Item No. **Report of the Head of Development Management and Building Control**

Address: 32 MILTON COURT ICKENHAM

Development: Erection of a part single storey, part two storey rear extension, a single storey side extension, a front porch, conversion of garage to habitable space, and conversion of roof space to habitable use to include 1 rear facing dormer, 1 side facing dormer, 2no. roof lights and formation of a crown roof.

LBH Ref Nos: 16332/APP/2025/1821

ADDRESS 32 Milton Court Ickenham UB10 8ND		
DRAWING TITLE Elevations proposed		
PROPOSAL Rear part double extension side single storey extension front porch, garage conversion Loft conversion		
SCALE 1:100	DATE May 25	REV
DRAWING NUMBER L.04

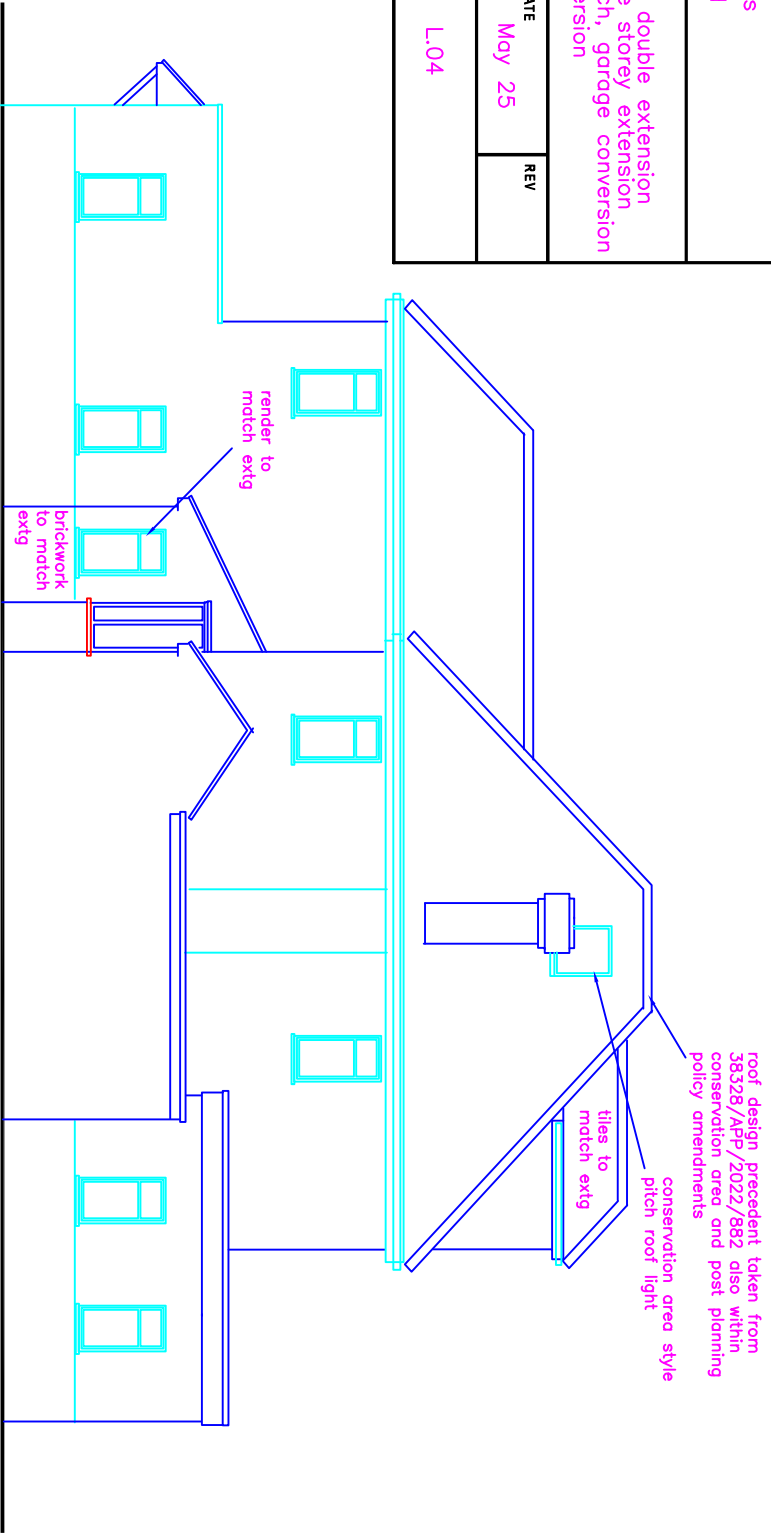
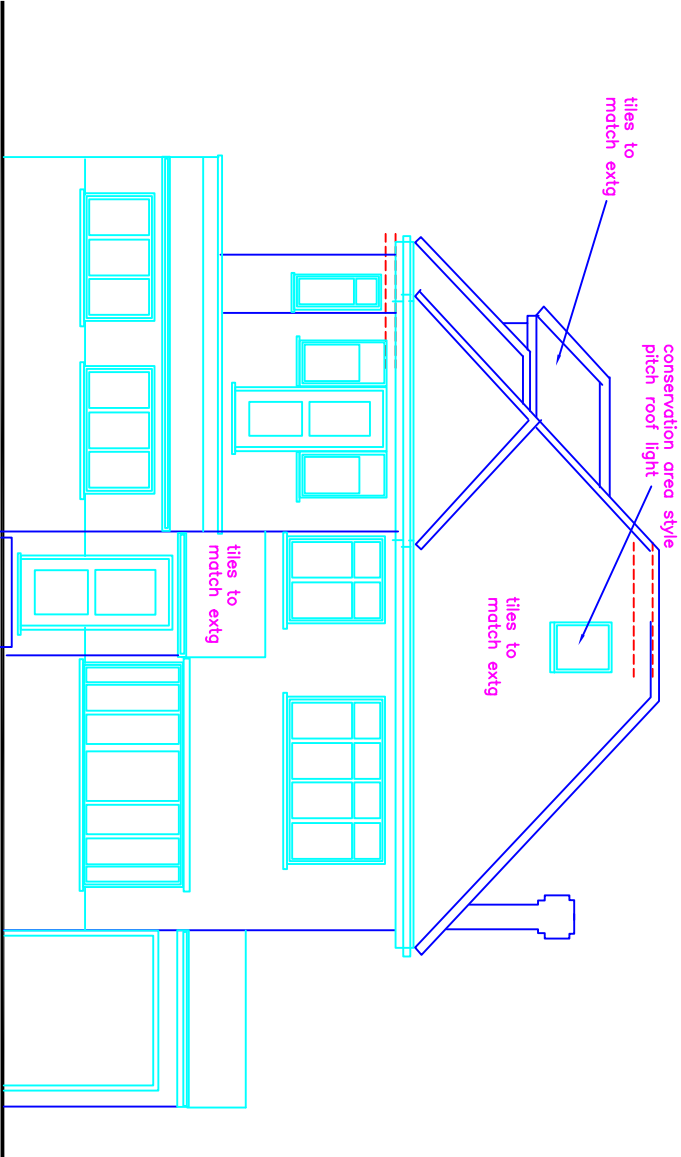
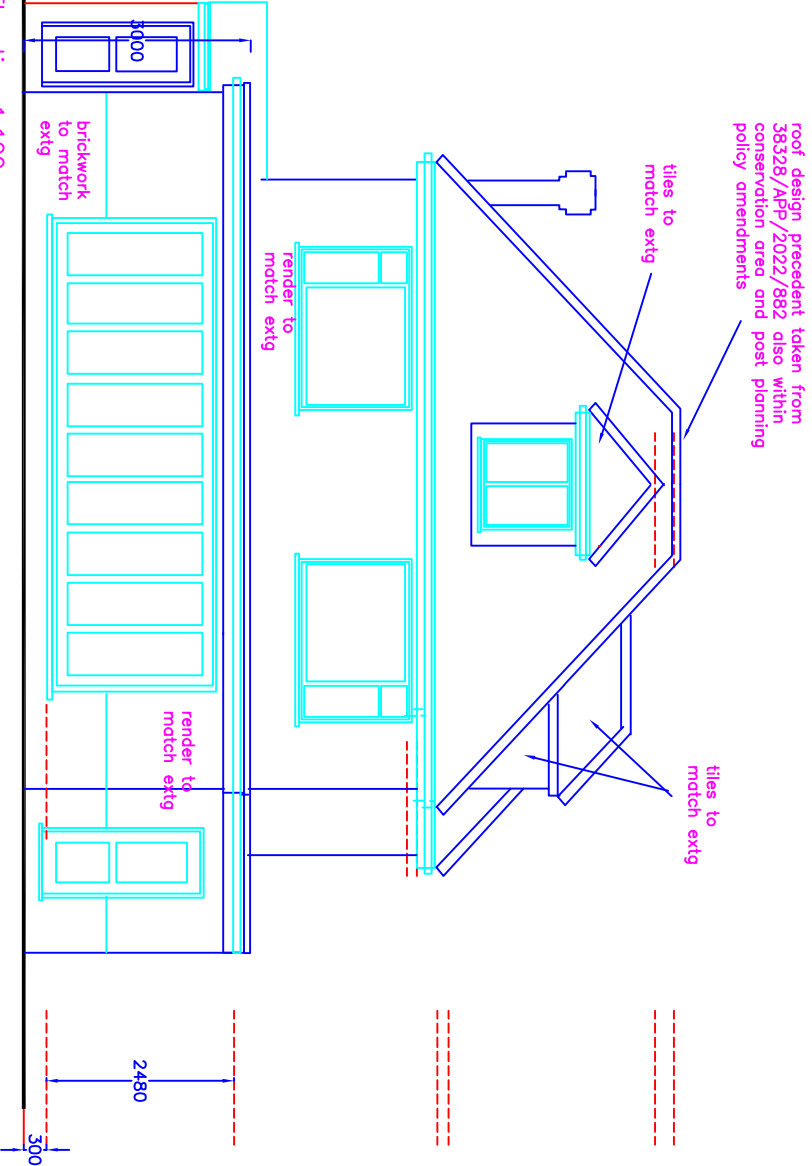
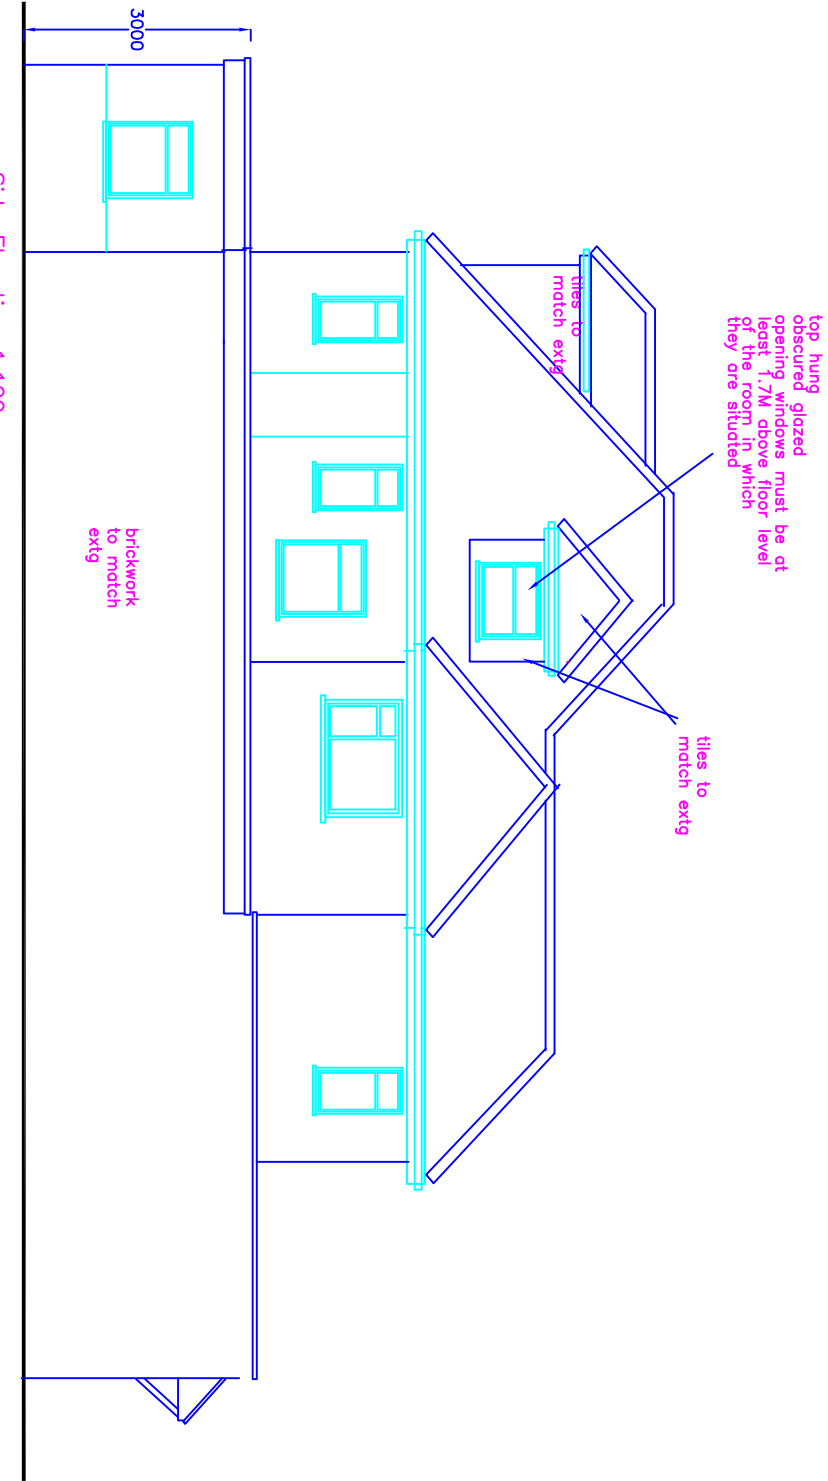
Moreover contrary to statements in the Heritage Statement the "bulk" of the proposed development appears to be out of character with the other properties in Milton Court, particularly the inclusion of the fashionable "crown roof."

Concern is raised regarding the dormer window along the side elevation which looks directly into the neighbour's window. The roof light along frontage should be removed. Otherwise the proposals are considered acceptable.

The proposed side dormer would be obscure glazed and non-opening below 1.7m from finished floor level and so there would not be an issue of loss of privacy or overlooking of neighbouring properties. Whilst the Council's Conservation Officer requested the removal of the proposed front rooflight, there are other properties within the street scene and the surrounding area that have rooflights on the front roof slopes. The proposed front rooflight would therefore not be out of keeping with the character and appearance of the street scene and surrounding area; a condition requiring the proposed front rooflight to be a 'Conservation Style' rooflight shall be added to any consent granted.

Although the Council's Conservation Officer requested the removal of the proposed front rooflight, there are other properties within the street scene and the surrounding area that have rooflights on the front roof slopes. The proposed front rooflight would therefore not be out of keeping with the character and appearance of the street scene and surrounding area. There is no objection to the proposed side rooflight. A condition requiring the proposed front rooflight and side rooflight to be 'Conservation Style' rooflights shall be added to any consent granted.

Whilst the Council's Conservation Officer raised overlooking concerns regarding the proposed side dormer window, given the proposed side dormer would be obscure glazed and non-opening below 1.7m from finished floor level, combined with the overall depth and width of the side dormer, and its position within the side roof slope, it is considered that the proposed side dormer would appear as a subordinate addition to the application property. The proposed side dormer would therefore not cause harm to the character and appearance of the application property and would preserve the character and appearance of the surrounding Ickenham Village Conservation Area.
